**48 Westbury Road,
New Malden,
KT3 5AX**

Design and Access Statement
in support of the
planning application

TOWN AND COUNTRY PLANNING ACT 1990 (AS AMENDED)
RE: 48 Westbury Road New Malden KT3 5AX

PROPOSAL: Erection of single storey rear extension, part single/part two storey side extension, and hip to gable and rear dormer roof extension to facilitate loft conversion.

<b>DRAWING TITLE</b> PROPOSED FIRST FLOOR PLAN	
<b>DRAWING NUMBER</b> AD/2306/22	<b>SCALE</b> 1:50 @ A1 1:100 @ A3
<b>REV.</b> 1

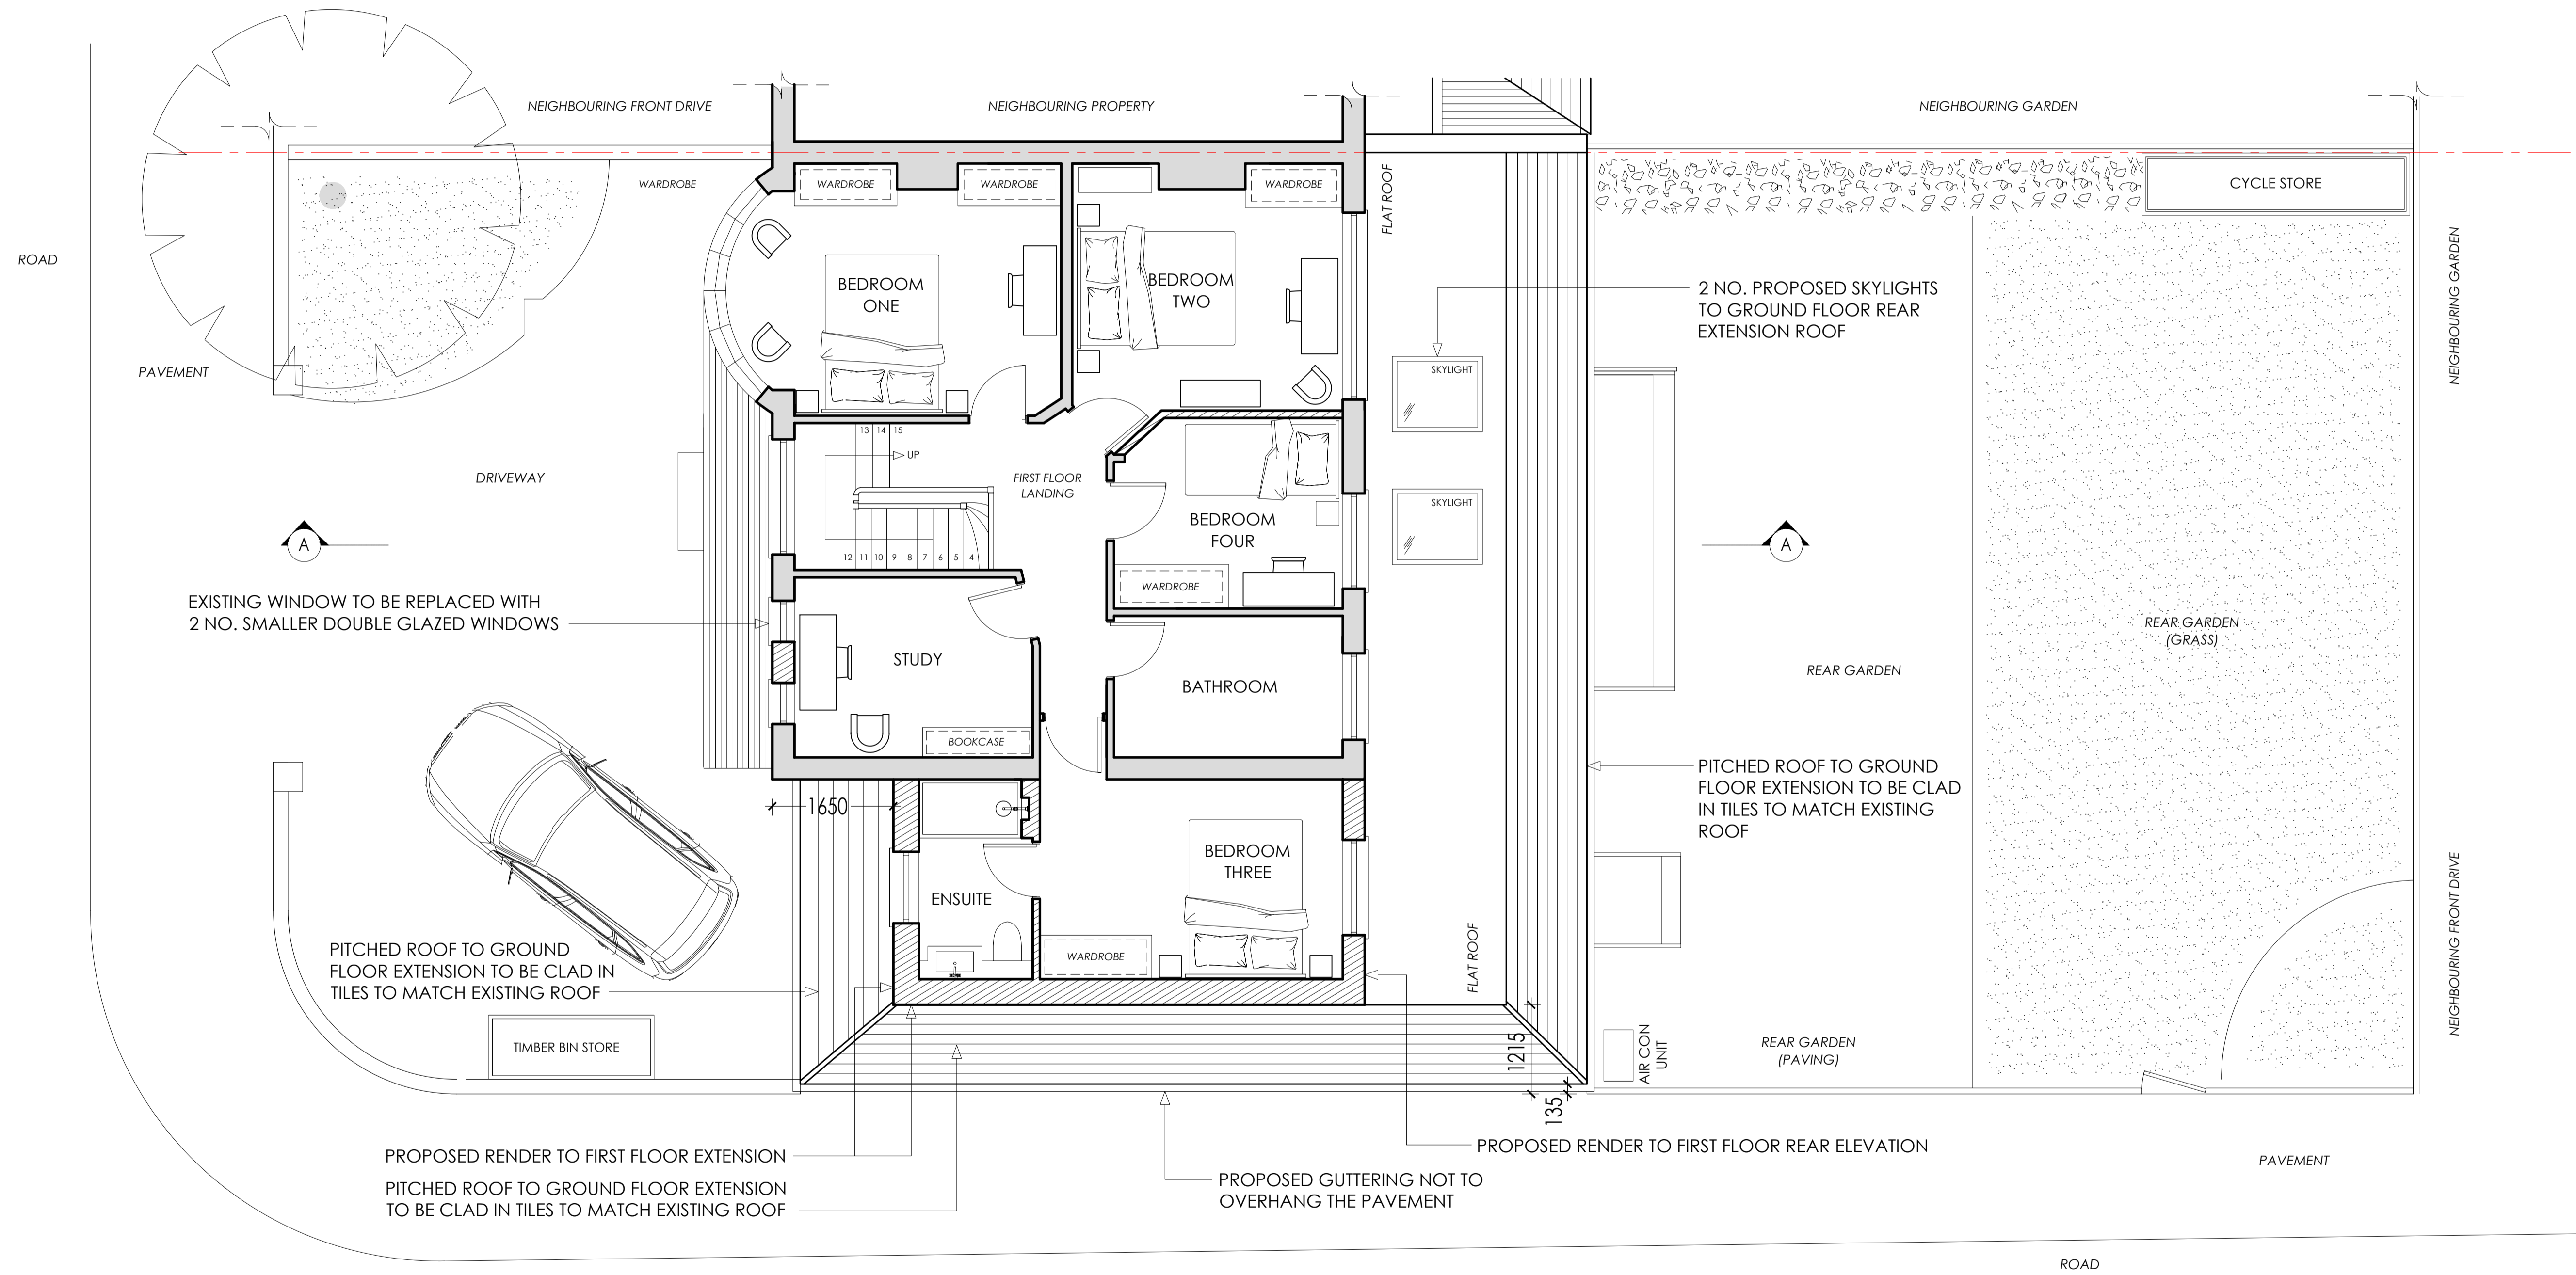
The proposed first floor side extension would be set back from the front elevation by approximately 1.65m and would be set in from the property boundary by approximately 1.2m. The proposed hipped roof would be in-keeping with the host dwelling and would have the roof line adequately set down from the existing one. However, the proposed roof would be slightly jarring within the context of the proposed hip to gable and large flat roof dormer extension which are also proposed.

- 6.5 The proposed first floor side elevation is to be set back as noted within the pre-application feedback.
- 6.6 During the pre-application meeting it was stated that the originally proposed flat roof and parapet wall may not be sympathetic to the surrounding context. Therefore a pitched roof is proposed to the ground and first floor extensions. This was shown to the planning officer and received favourable feedback.

DRAWING TITLE EXISTING AND PROPOSED PARKING PLAN		
DRAWING NUMBER AD/2306/39	SCALE 1:150 @ A1 1:300 @ A3	REV. 1

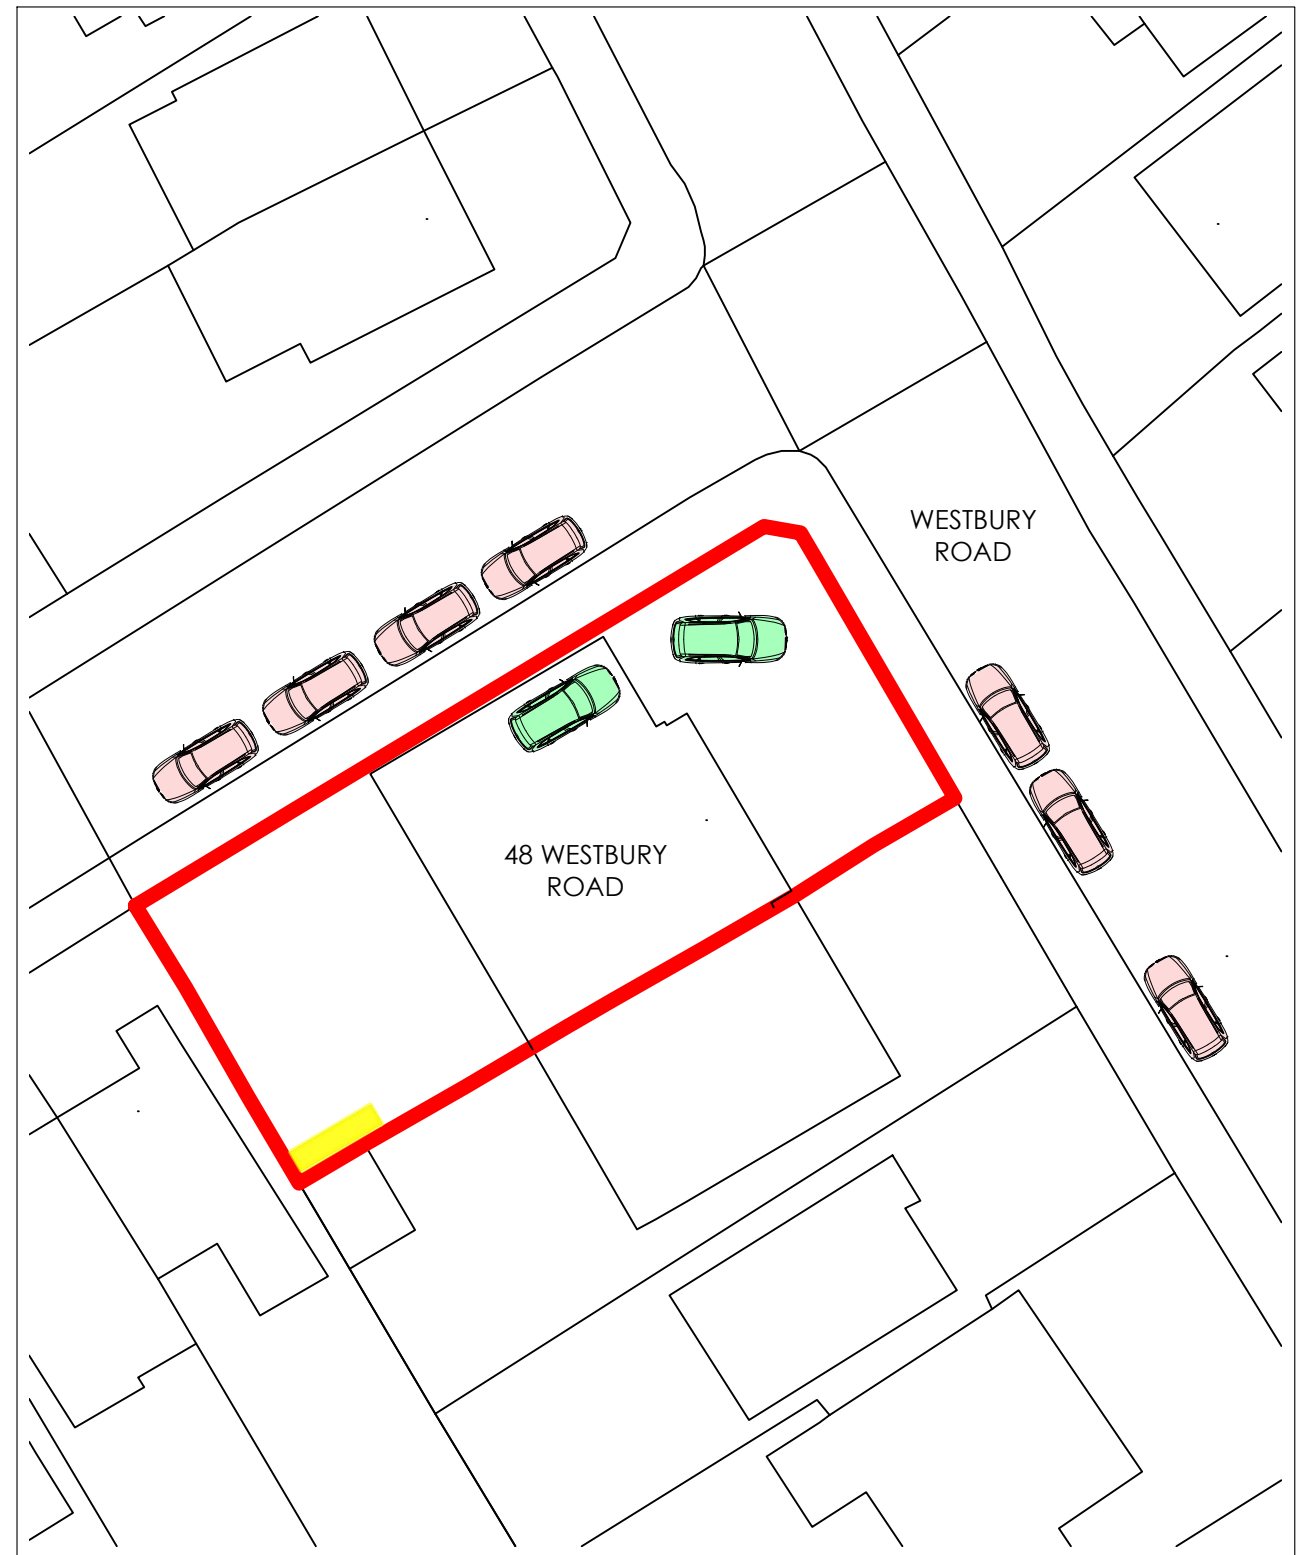
The proposal would include provision of a garage which is considered of an adequate size to park a car. Officers note the hardstanding to the front of the dwelling remains of an adequate size to accommodate 1 off street car parking space, therefore the proposal would not result in an unacceptable impact on the local highway network.

In relation to cycle parking, the applicant has indicated secure cycle parking provision in the rear garden.

DRAWING TITLE PROPOSED GROUND FLOOR PLAN	
DRAWING NUMBER AD/2306/21	SCALE 1:50 @ A1 1:100 @ A3
REV. 1

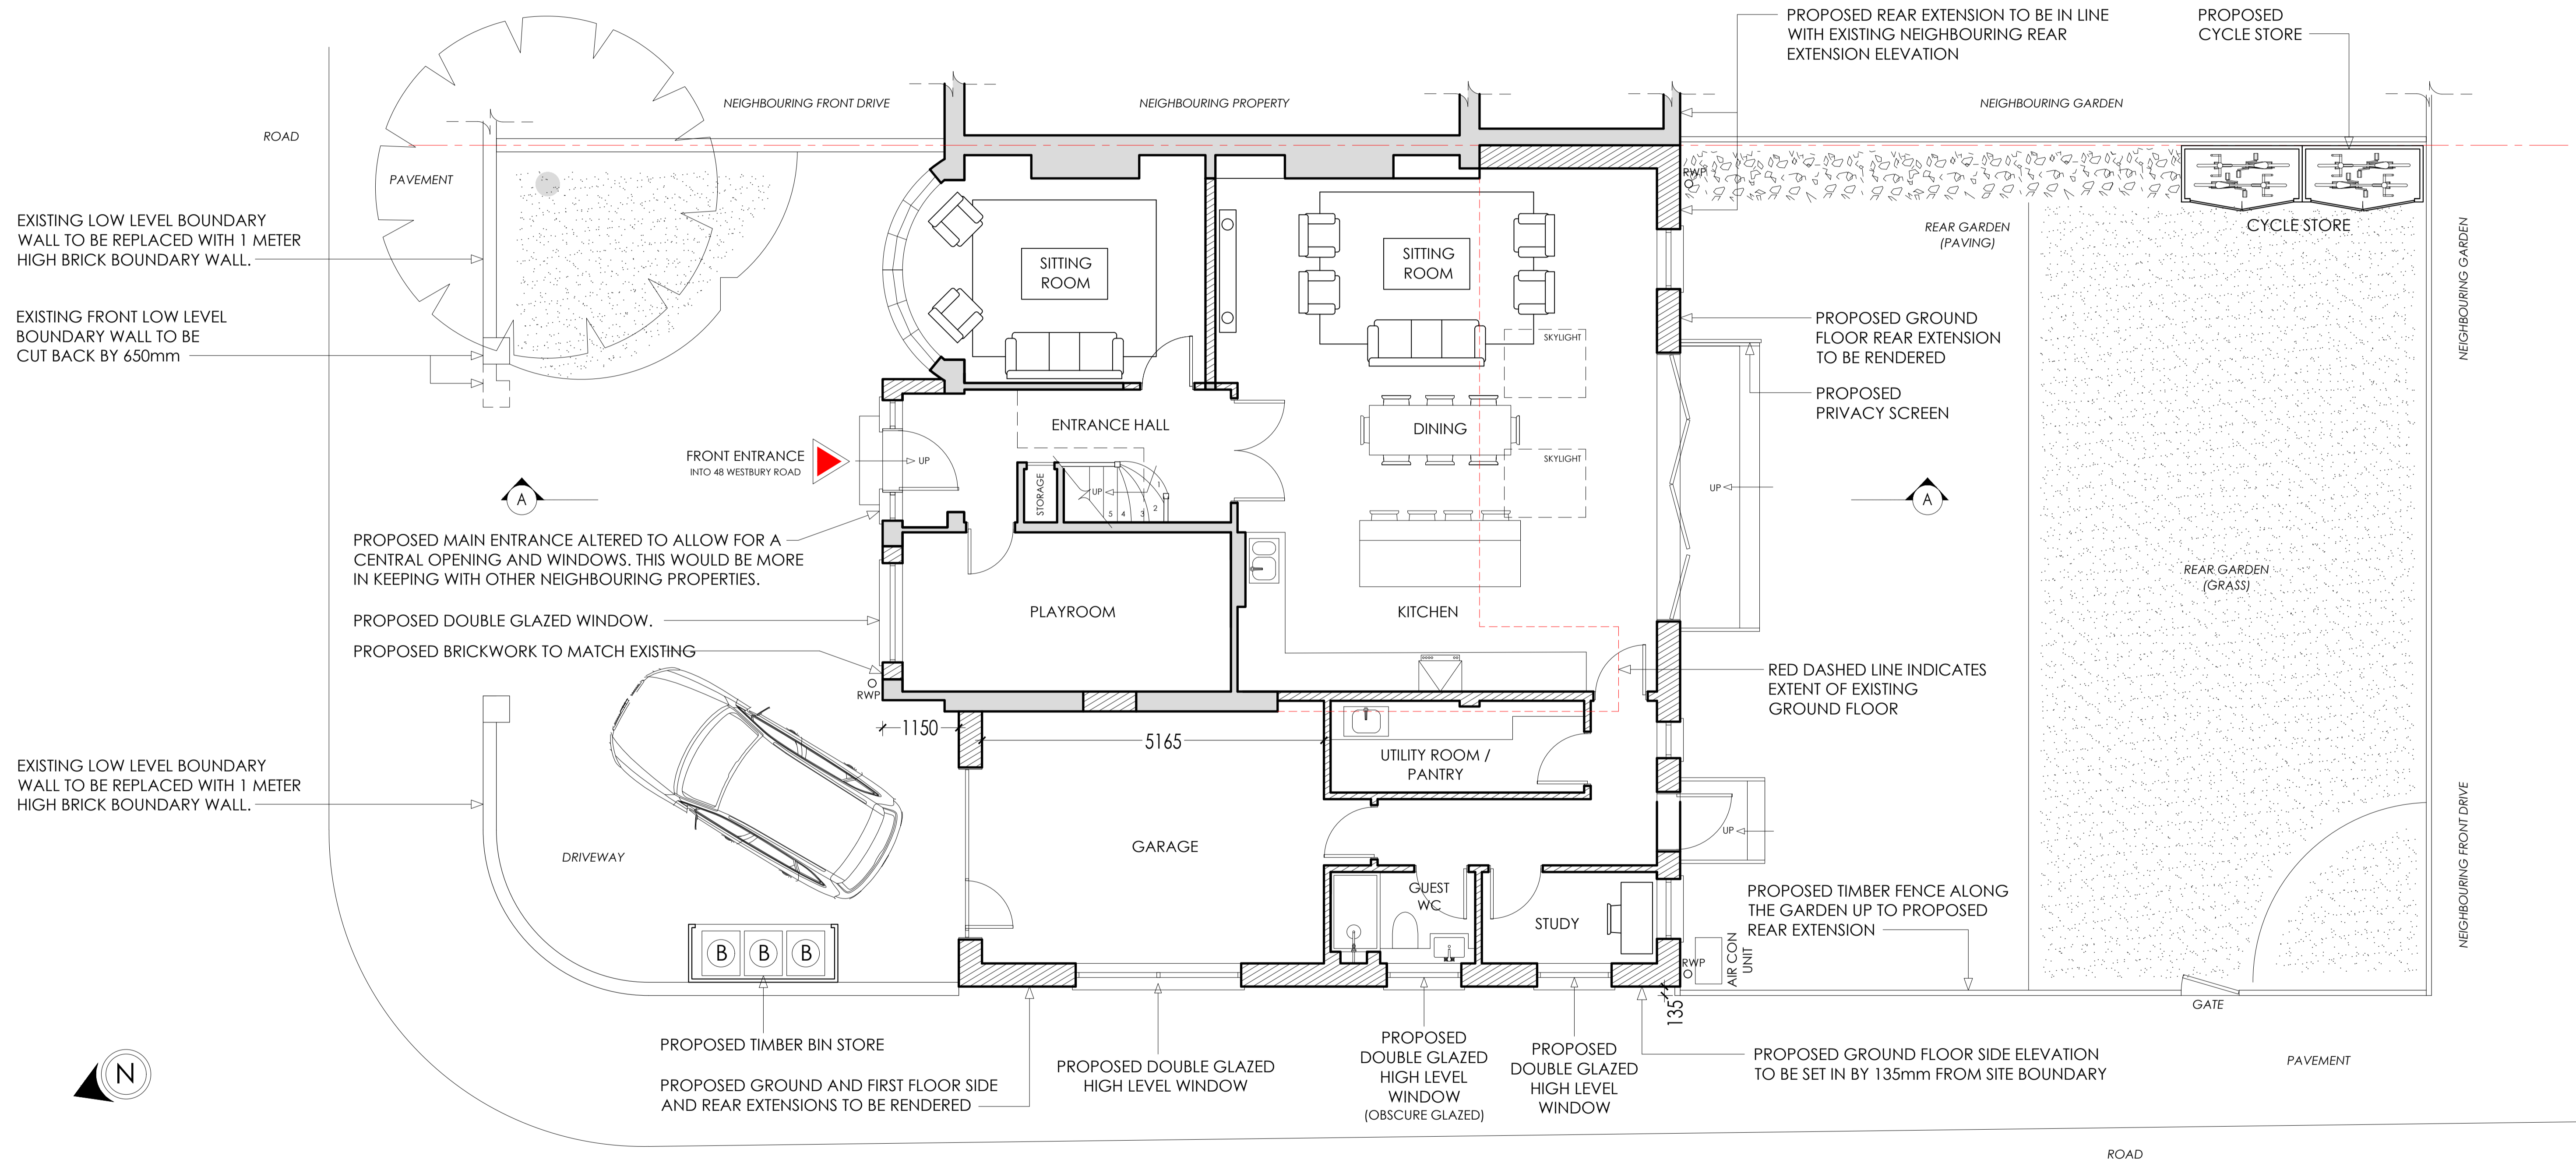
The proposed ground floor side extension would be set back from the front elevation and would have a width of approximately half of the width of the original house. The proposed separation distance of approximately 150 mm to the property boundary, although not strictly in accordance with Policy Guidance 36 of the Council's Residential Design SPD it would be acceptable given the siting of the application site and similar extensions within the existing street scene.

While the proposed two storey side extension is, in isolation, in general compliance with the Policy Guidance 36, there are some concerns as to how it would sit within the other extensions to the property. The proposed pitched roof to the ground floor extension instead of the parapet roof (as per originally submitted proposed plans), is considered to be a better option, however, care will need to be taken to ensure that guttering does not overhang the pavement.

The proposed single storey rear extension would feature part flat part pitched roof, which is considered to relate well to the host dwelling. The proposed depth and height of the extension would be in accordance with Policy Guidance 33. It is considered that the proposed rear extension would appear as a proportionate and subordinate addition to the host dwelling. Differences in ground levels are noted. A set in of 250mm from the site boundary should be incorporated, as per Policy Guidance 35 of the Residential Design SPD (2013).

- 6.7 The proposed ground floor side elevation is set in by 250mm as requested within the pre-application feedback.
- 6.8 A privacy screen has been added to the proposed steps to the ground floor rear extension as requested within the pre-application feedback.
